CITY OF PORTLAND, MAINE  
DEVELOPMENT REVIEW APPLICATION  
PLANNING DEPARTMENT PROCESSING FORM  
DRC Copy

Garsoe Drive (lot 3)

RE: 27 Garsoe Drive Site Plan Application  
(#2001-0062) (CBL 386 AA003)

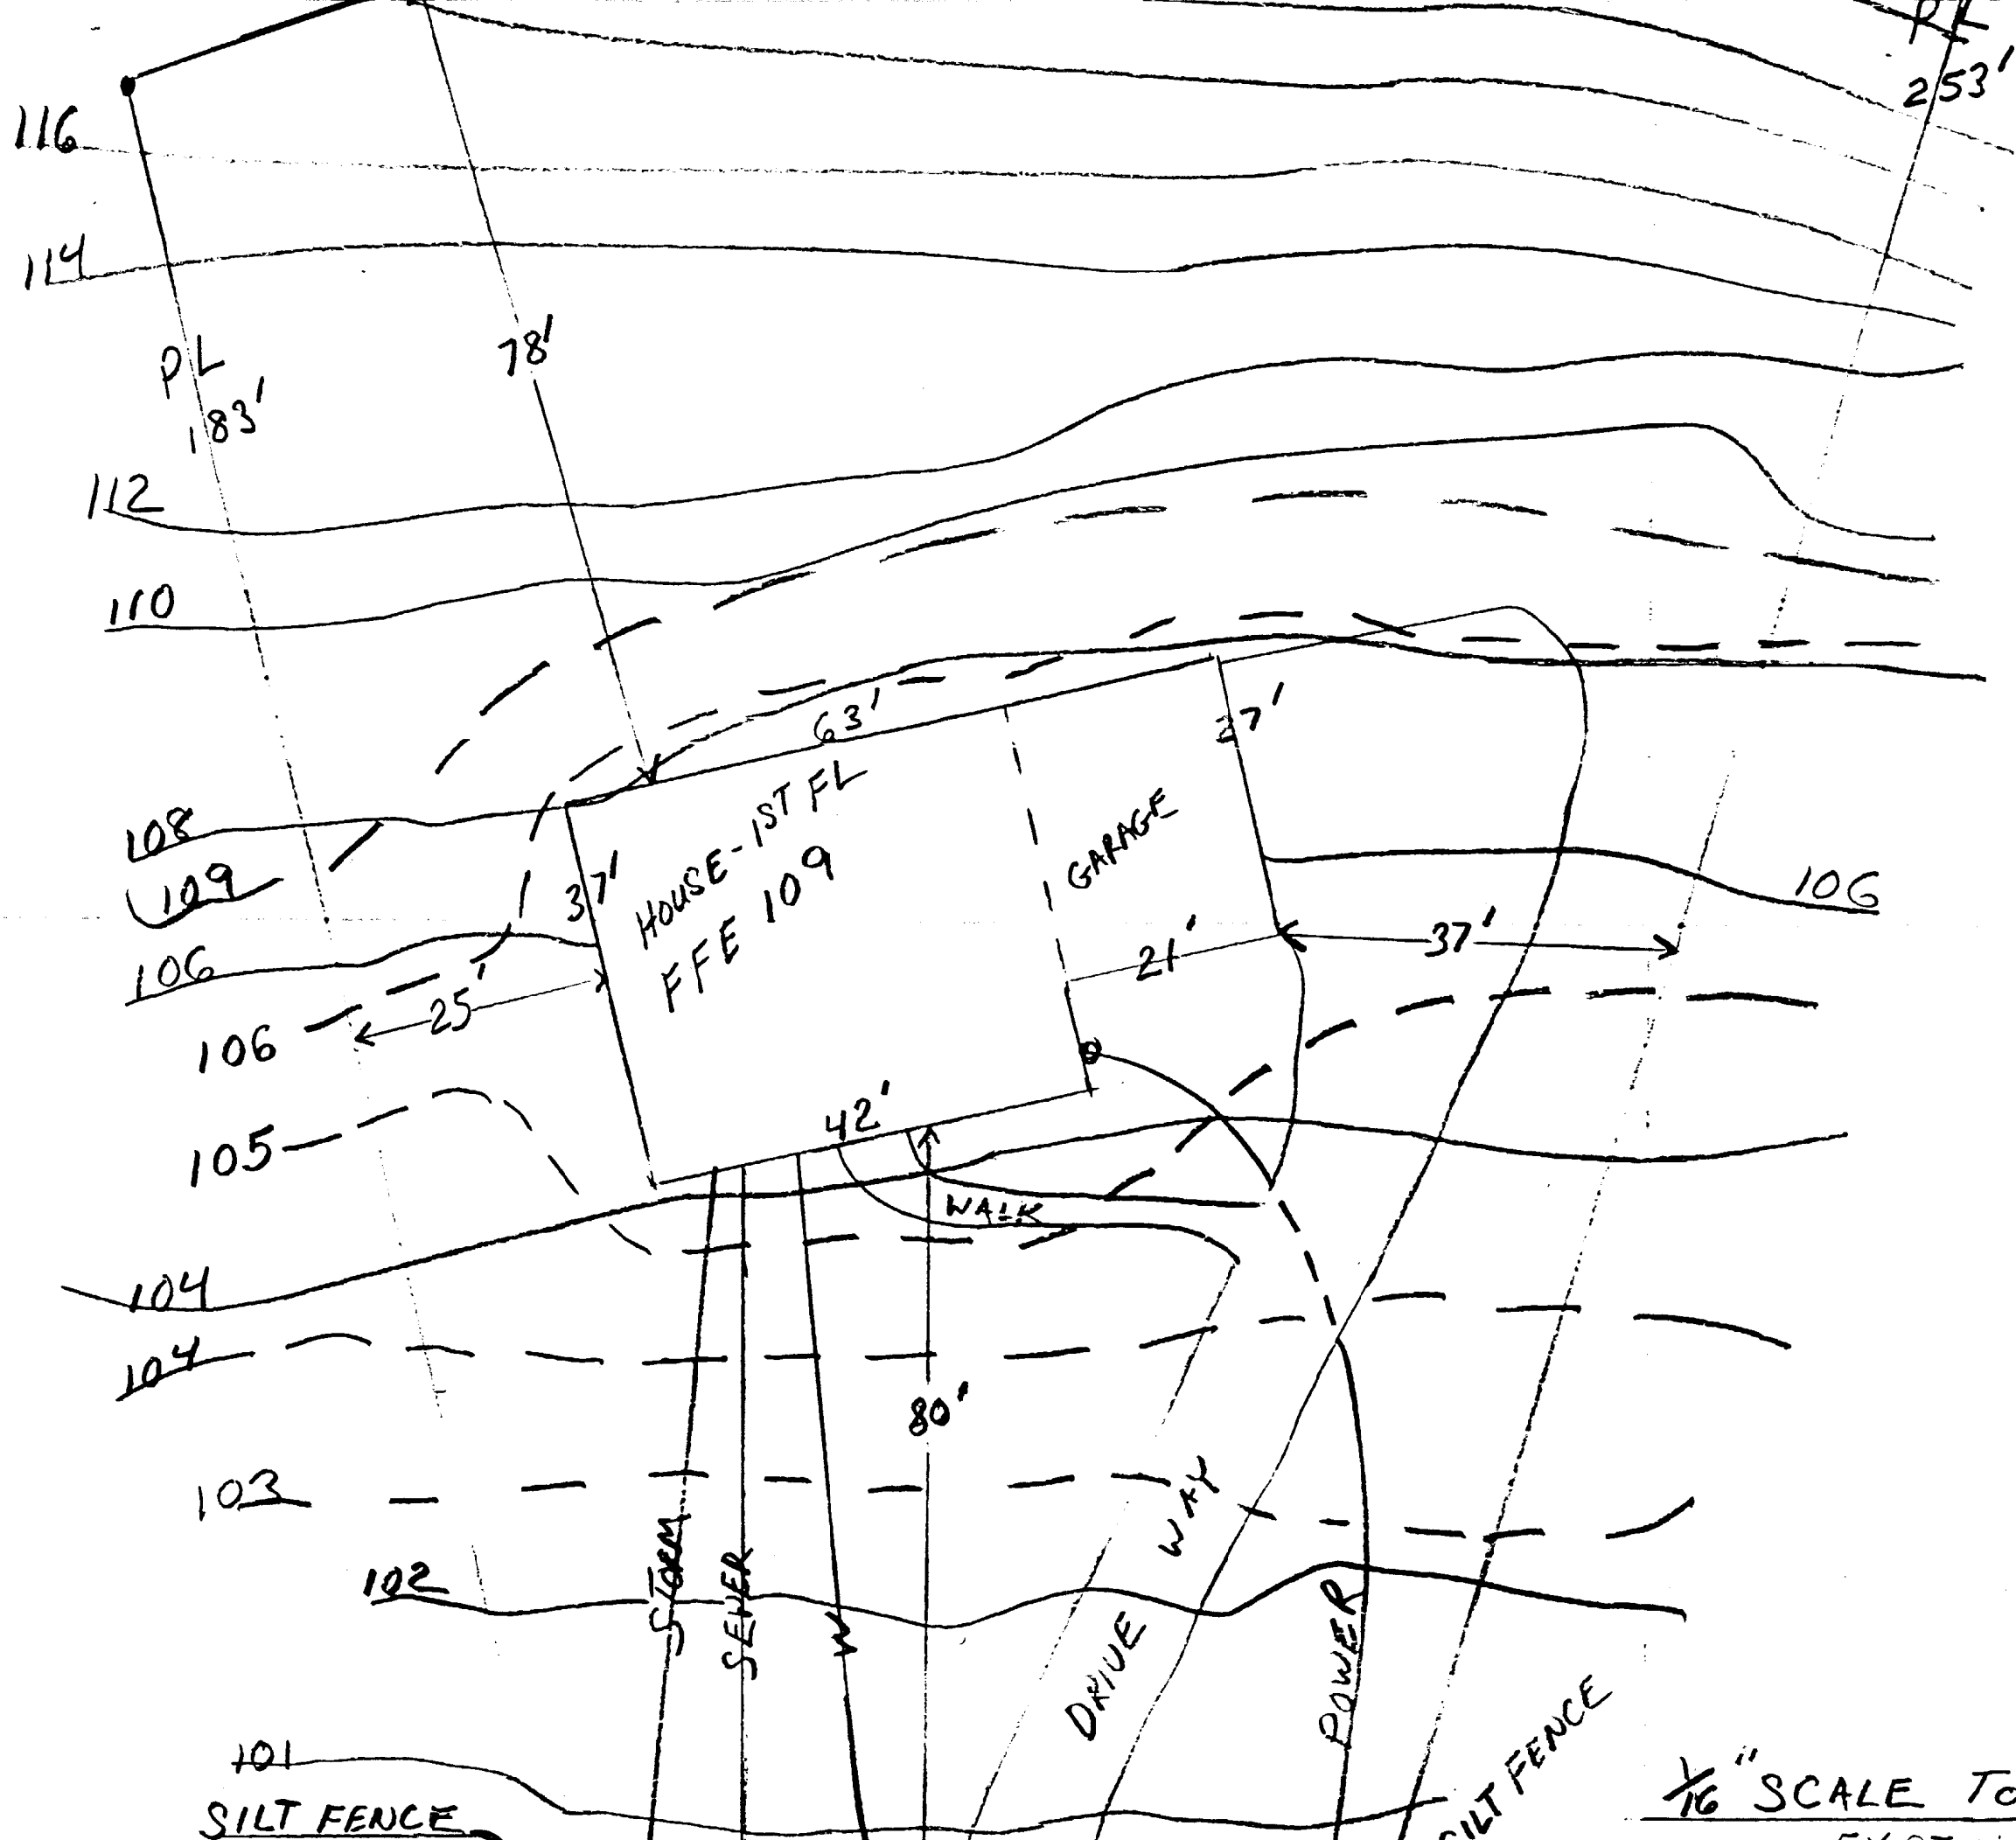
- 1 TWO TREES (REQUIRED) ALONG THE FRONTAGE OF THE PROPERTY ARE NOT SHOWN ON THE PLAN. TREES MUST BE IN PLACE PRIOR TO ISSUANCE OF A CERTIFICATE OF OCCUPANCY.
